Your ref:
Our ref: 23/01272/F
Please ask for: Miss Sandra Homcenko
Direct dial: 01553 616824
E-mail: borough.planning@west-norfolk.gov.uk

Details: **Conversion of retail unit to 2no. retail units and ground floor flat at Value 4 Money 48 Westgate Hunstanton Norfolk PE36 5EL**

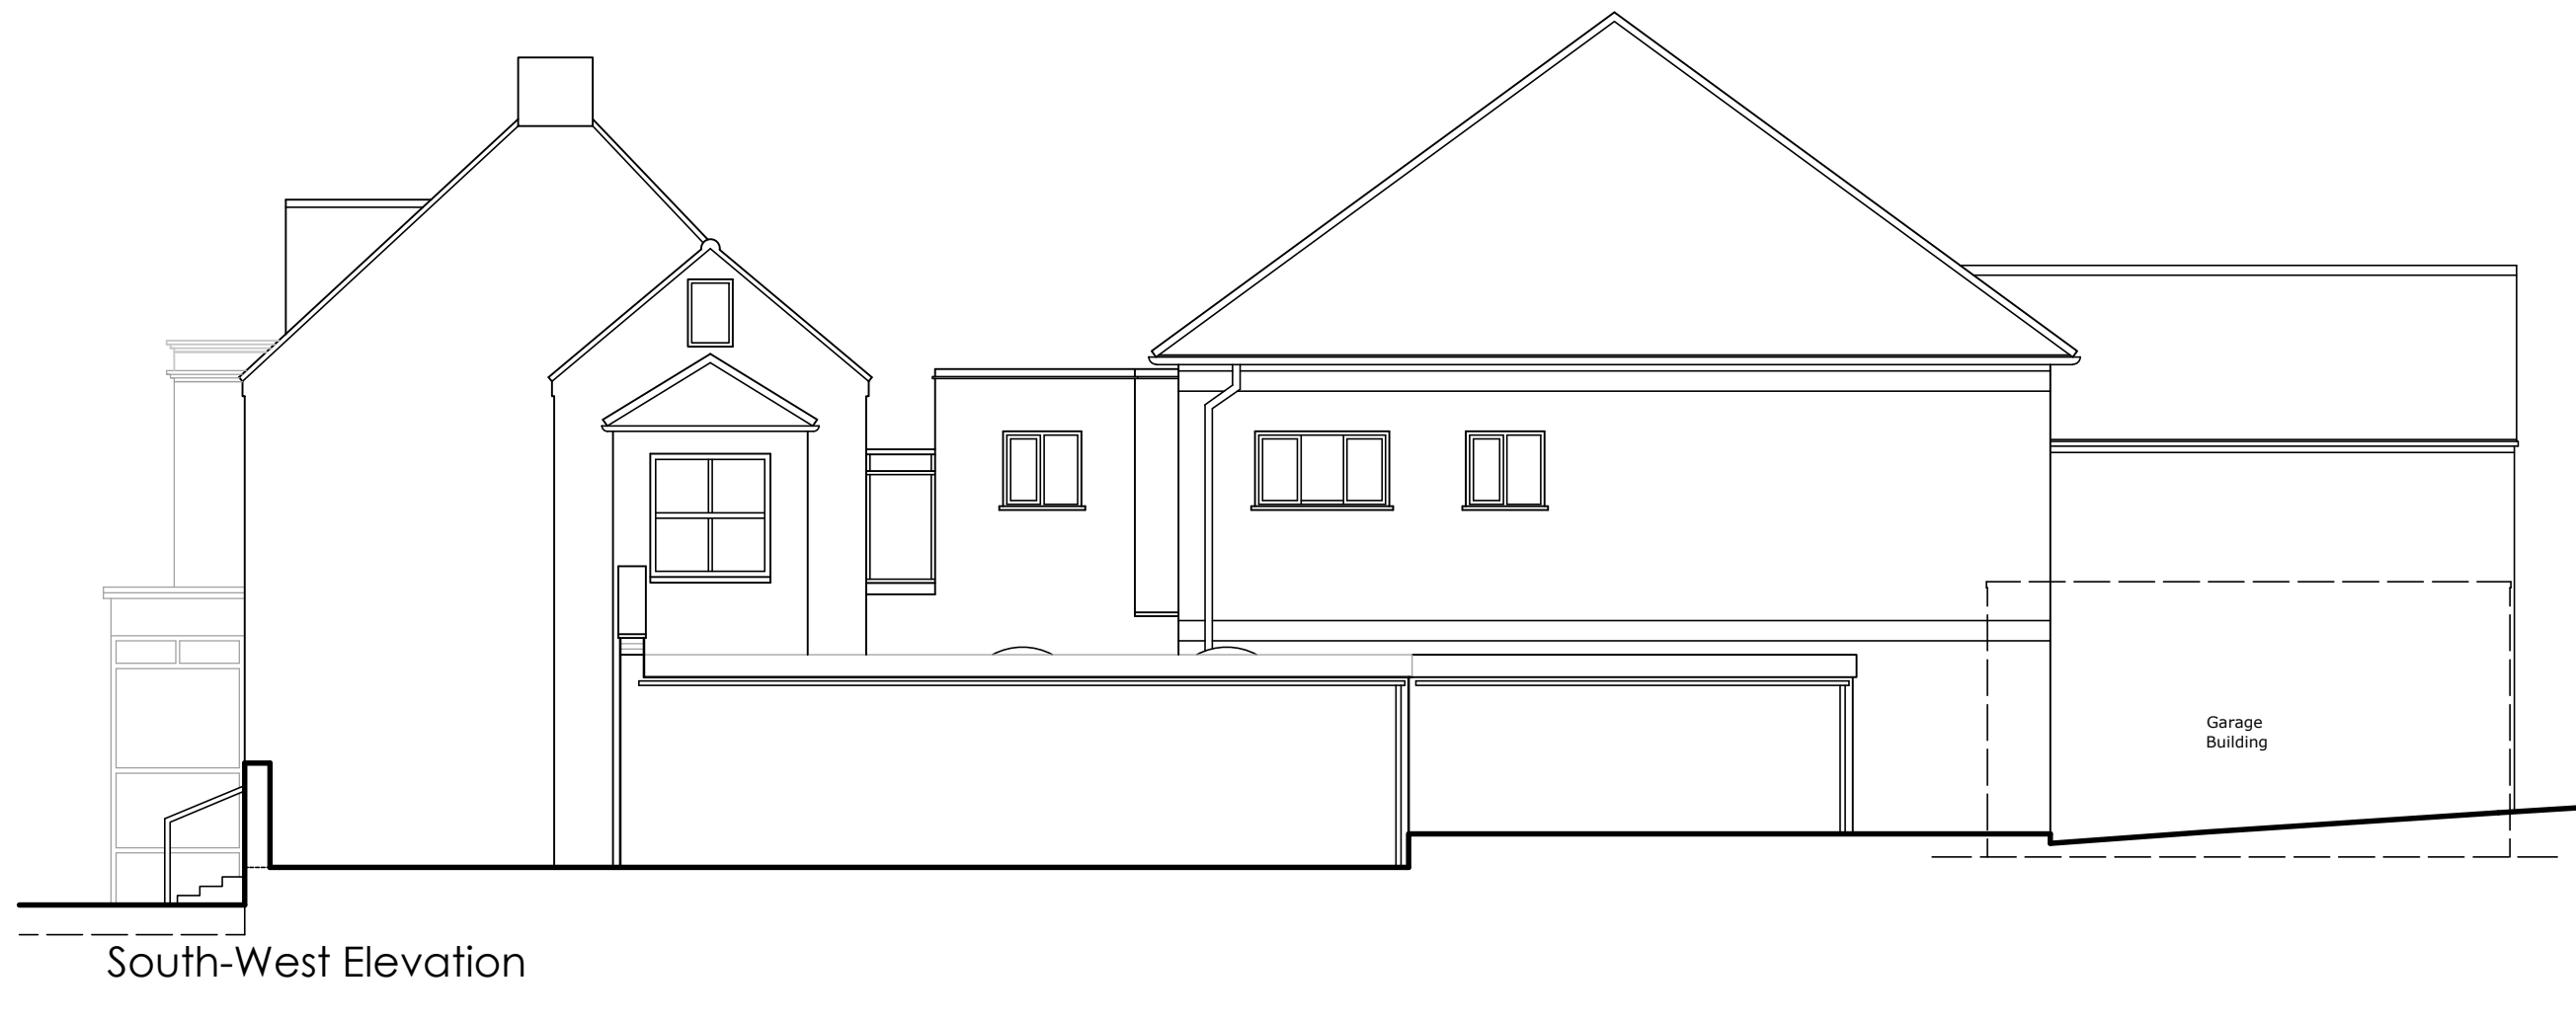
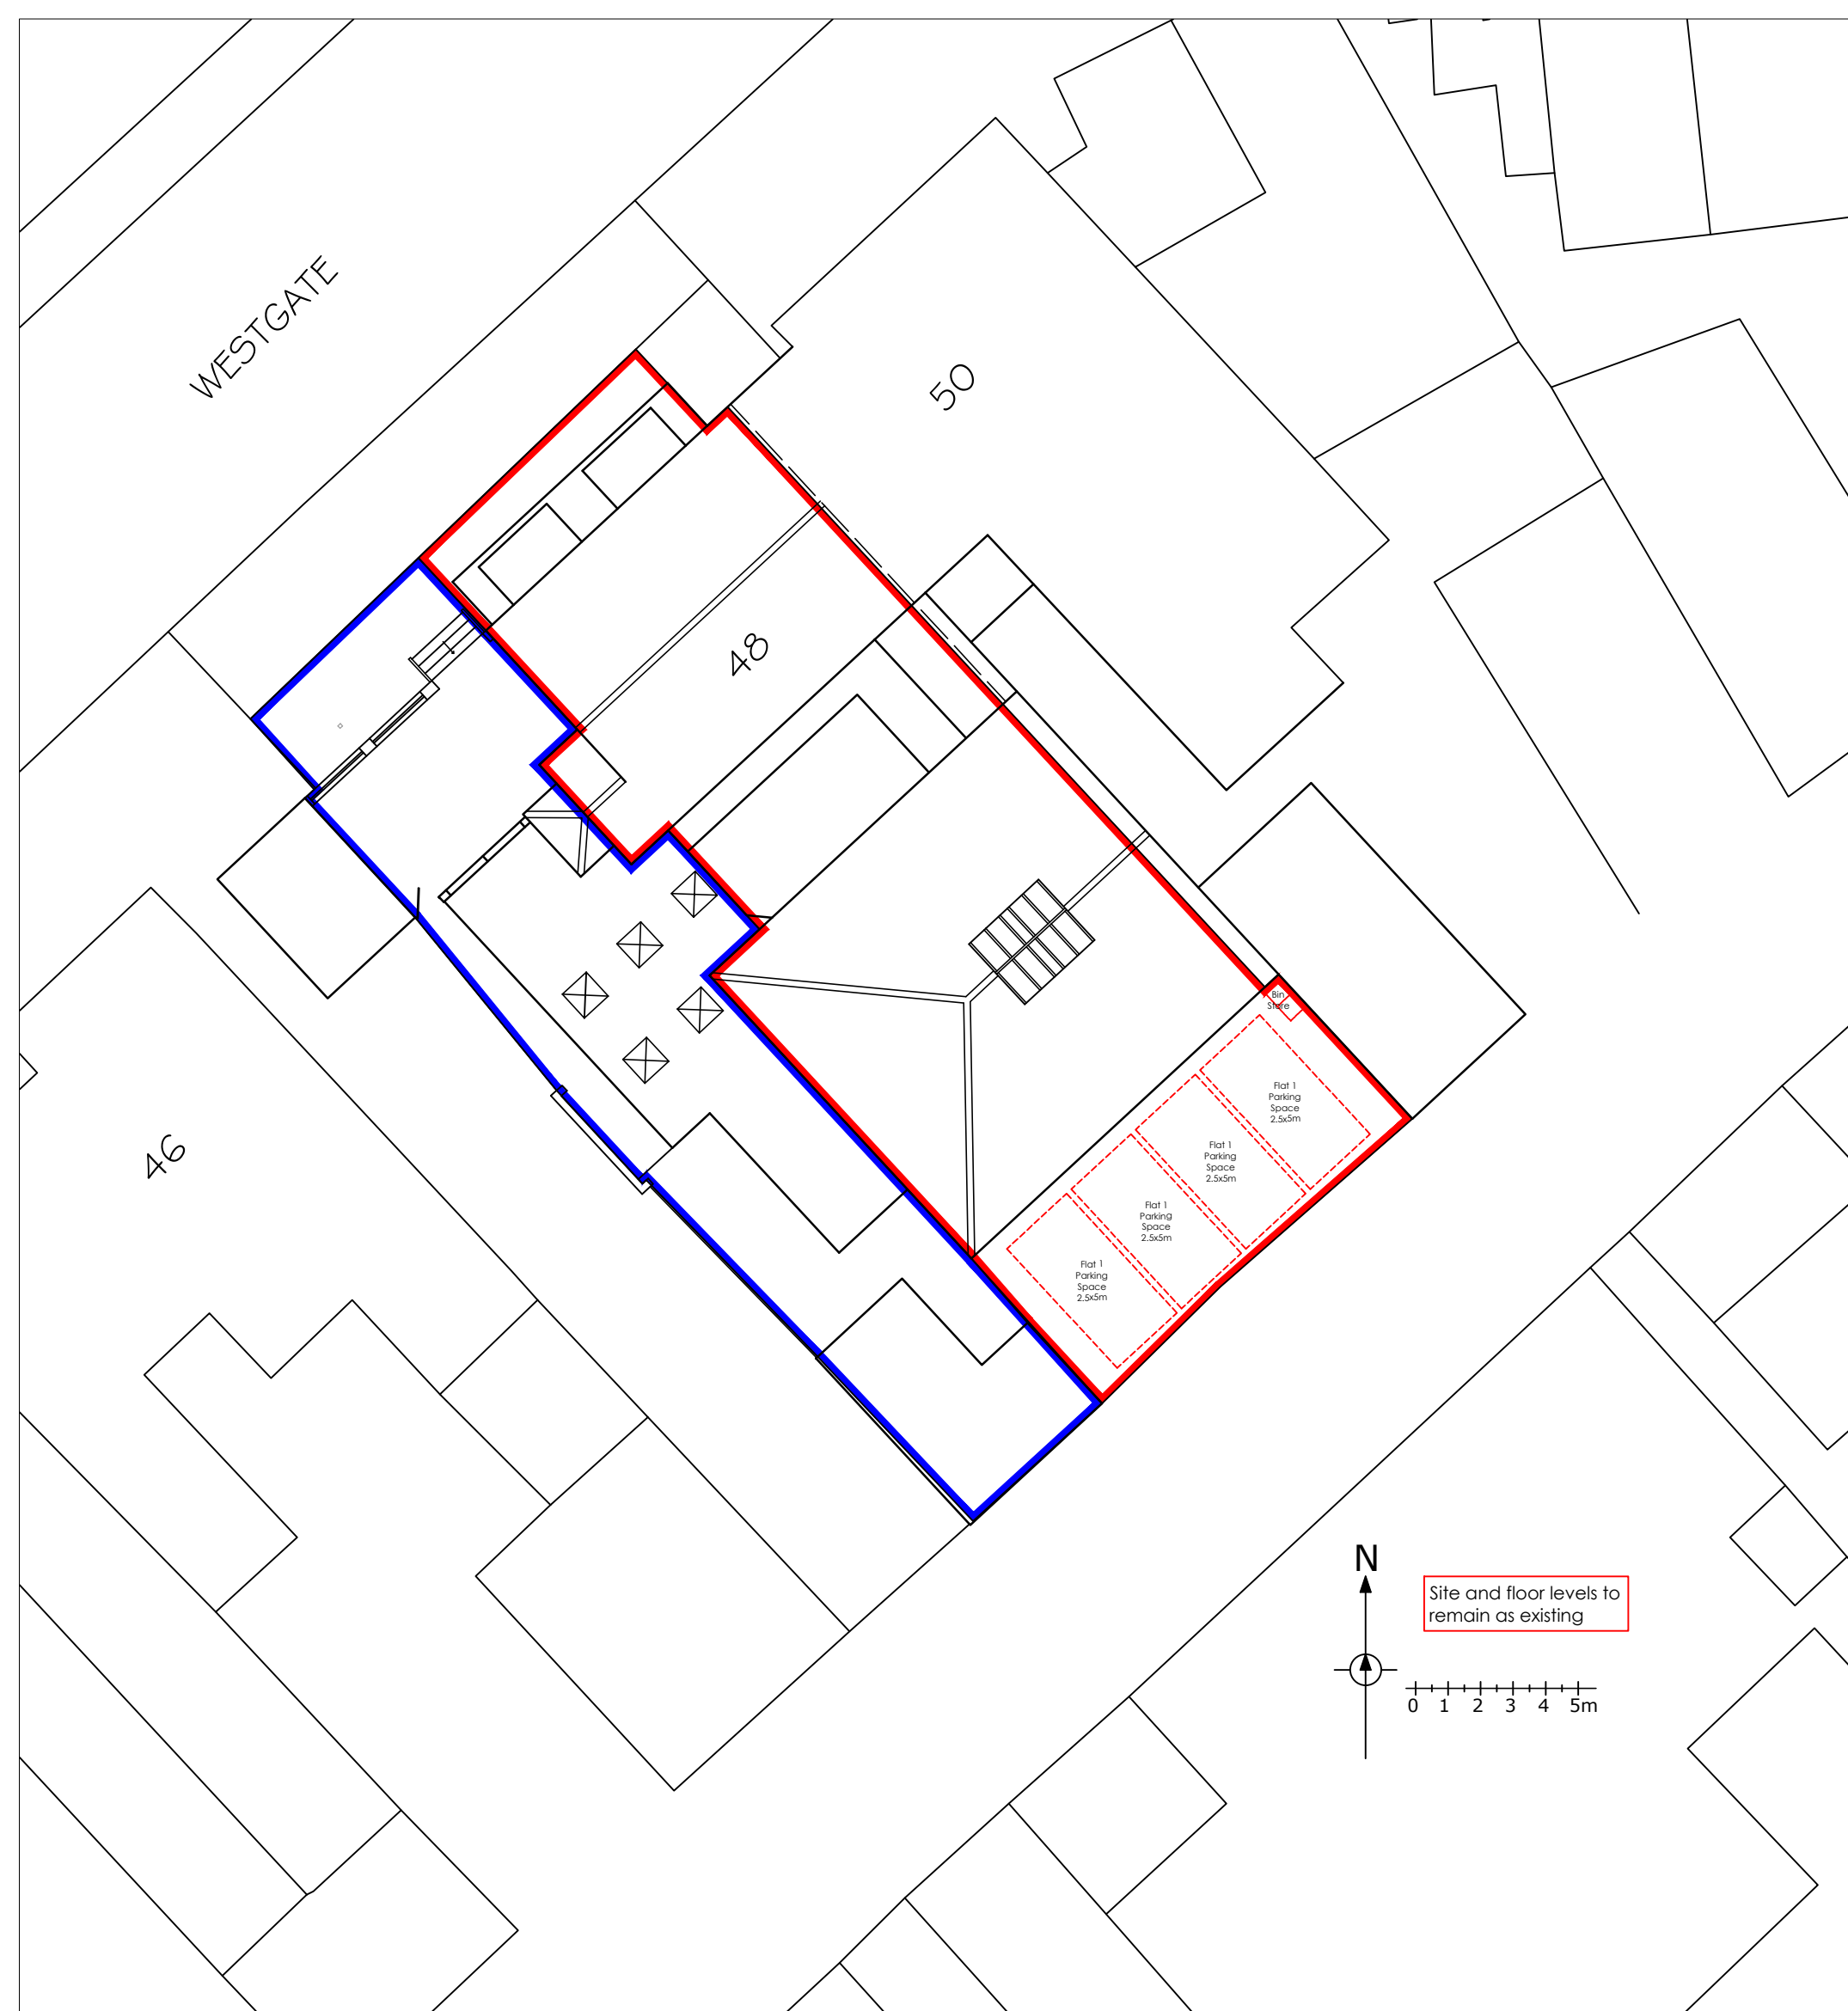
1. Please revise frontage of the building on proposed plans as elevations do not match floor plans.
2. Please clearly indicate access to the new dwelling
